From: Anita Gardner
Sent: 04 November 2009 12:49
To: Planning.Responses
Subject: FW: Planning application FN/56/09 - proposed caravan site at Long Furlong Findon

From: Trevor Sennett
Sent: 04 November 2009 12:29
To: Anita Gardner
Subject: Planning application FN/56/09 - proposed caravan site at Long Furlong Findon

I have viewed the proposal for a 14 unit touring caravan site on the above site and have the following comments:

PLAN 1/50 TOILET BLOCK

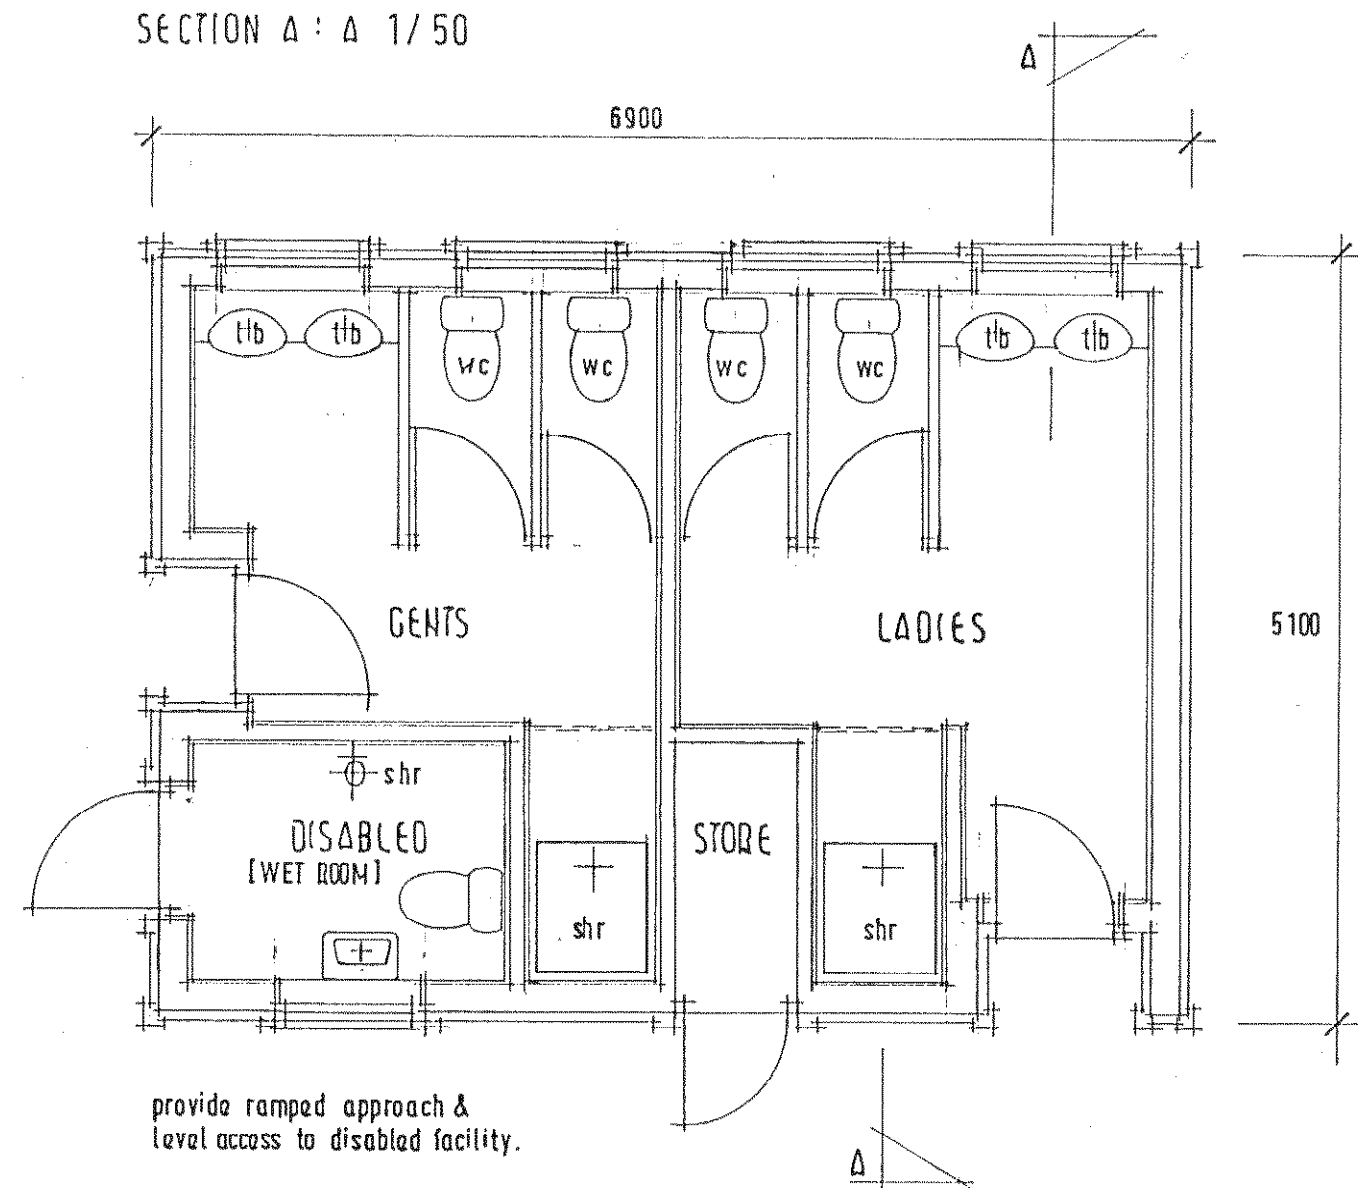
The proposal meets the model standards for a touring caravan site in terms of sanitary and drainage provision, spacing and water supply and access arrangements. It is pleasing to note that the sanitary block has been designed with disabled users in view.
